Application by Meridian Solar Farm Limited for an Order Granting Development Consent for the Meridian Solar Farm.

Following the Planning Inspectorates Rule 8 letter dated 15 September 2026 the County Council submits its Written Representation (WR) in respect of this application. The Council provided initial comments in relation to this application in its Relevant Representation (RR) response earlier this year and full details on the impacts of the development in our Local Impact Report (LIR) submitted 22 September 2026 at deadline 1.

The WR has been prepared having regard to MHCLG examination stage guidance and should be read in conjunction with the Council's LIR submitted by the Council at deadline 1. The LIR was brought to the Council's September Planning and Regulation Committee when it was resolved to approve the document for submission to the Examining Authority. Based on the findings of the Local Impact Report, the Council resolved to submit a **formal objection** to the application on the following grounds.

Figure 3-7 Flood Risk Planning Map

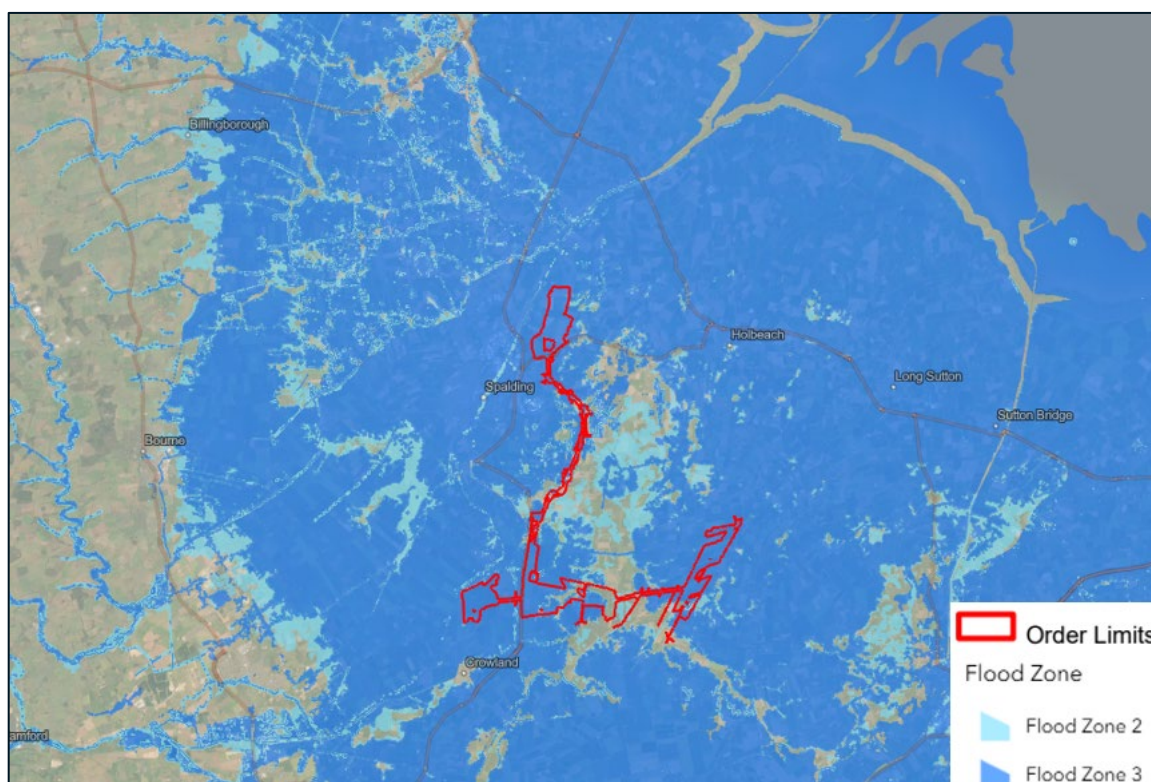
Water Resources and Flood Risk – From a policy perspective there are concerns over whether the strategic site selection process and application of the sequential and exceptions tests have been undertaken in a robust manner and whether consideration of alternative, smaller land parcels may

have led to a development proposal occupying less land sited in areas of high flood risk. Pending further information and clarification from the Applicant on this latter point, the development is currently considered to be contrary to development plan policies 2 (Development Management), 3 (Design of New Development), 4 (Approach to Flood Risk) and 31 (Climate Change and Renewable and Low Carbon Energy) of the SELLP.

Figure 3-10 Field averaged survey results

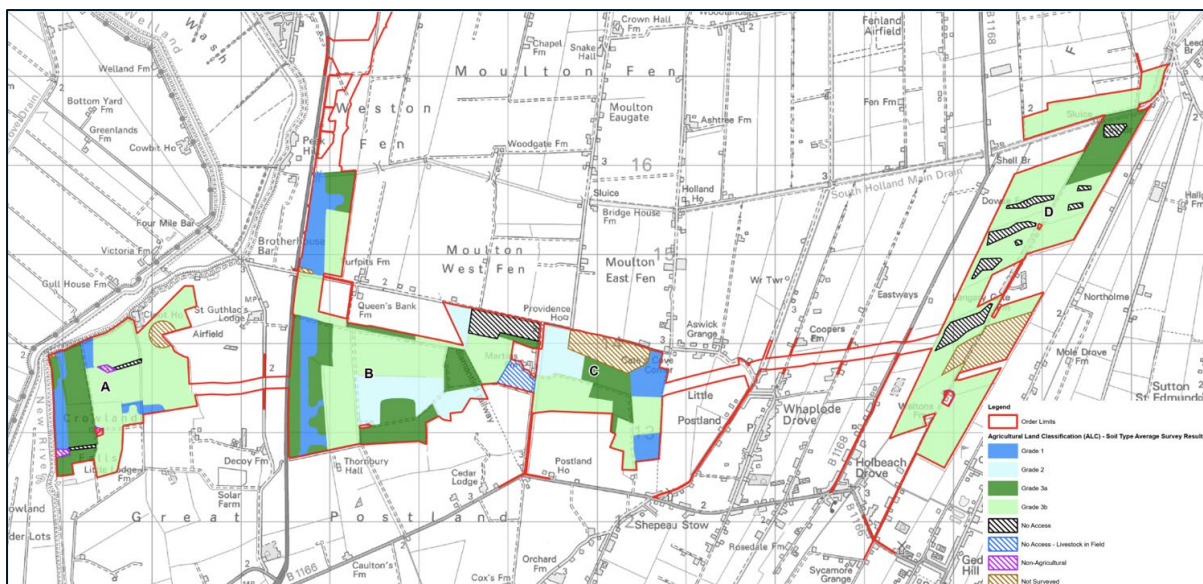
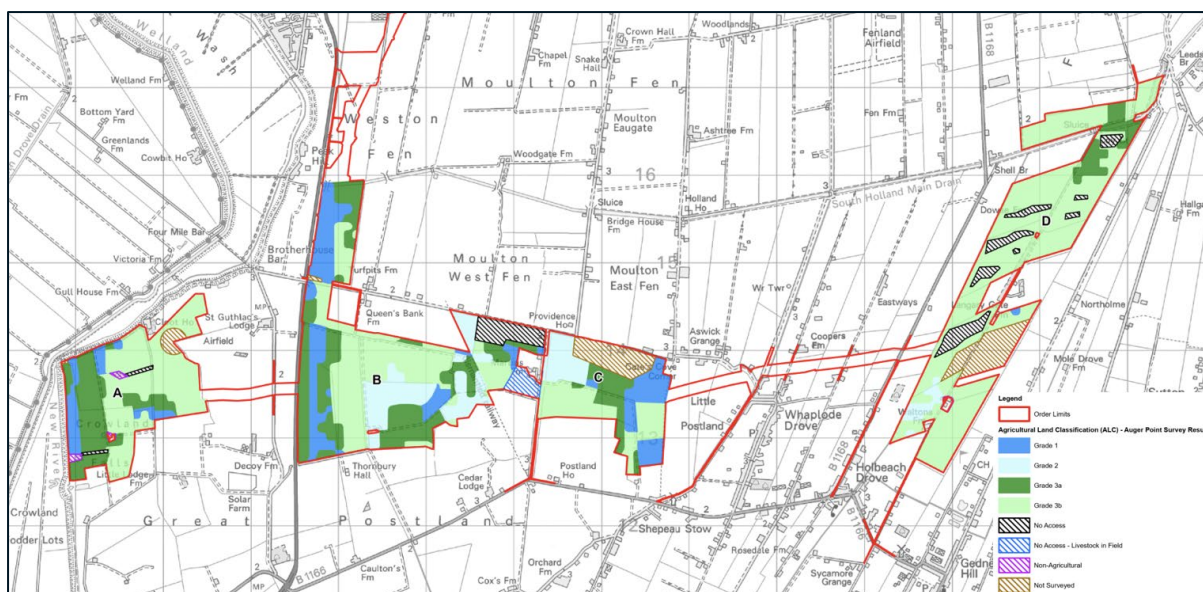
Soils, Agriculture and Land Use - The development would result in adverse impacts on BMV land by taking a significant area of agricultural land out of production for 40 years. There are significant concerns over the validity of the ALC survey undertaken, the results from which run contrary to, and are not supported by, existing published literature. In combination with other solar developments already permitted and potentially in the pipeline for Lincolnshire, the cumulative effects of agricultural land being taken out of production are proportionately significantly higher than other parts of the country. The ES fails to take account of the economic and other benefits of BMV land, as required by policy, nor any socio-economic impacts. The development is therefore considered to be non-compliant with SELLP policies 3 (Design of New Development), 30 (Pollution) and 31 (Climate
